TNP PROJECT NUMBER: ADD 01333

WRIGHT BROTHERS / WILEY POST

WATER LINE REPLACEMENT

Const. mark-up

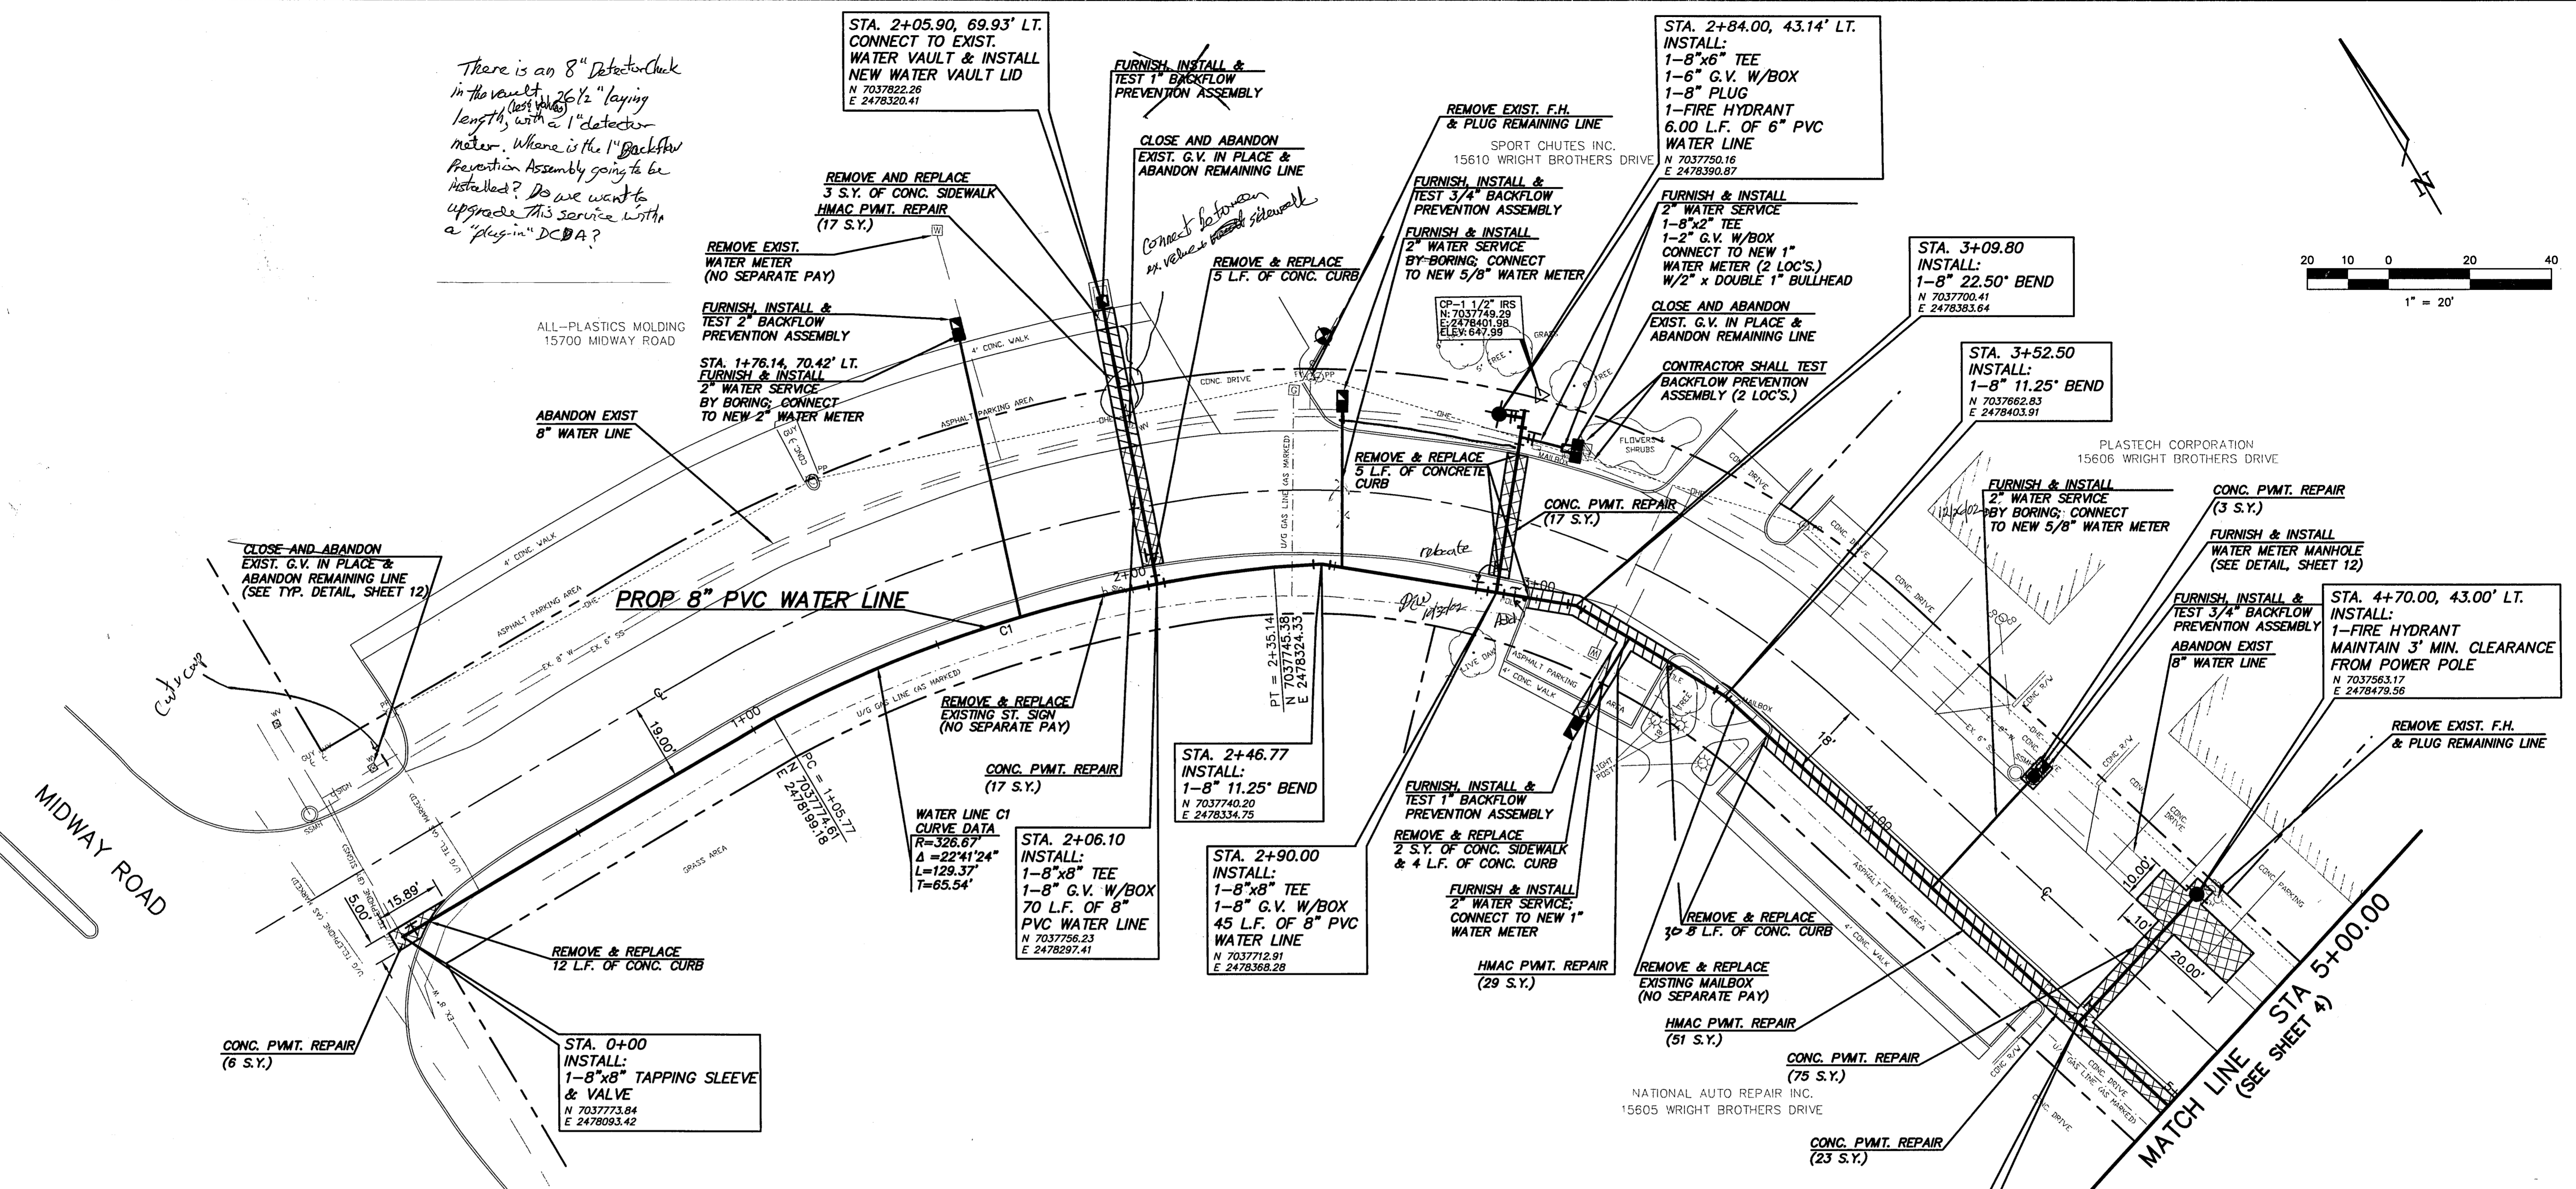
There is an 8" Detector Check in the vault (last 26 1/2" laying length) with a 1" detector meter. Where is the 1" Backflow Prevention Assembly going to be installed? Do we want to upgrade this service with a "plug-in" DCBA?
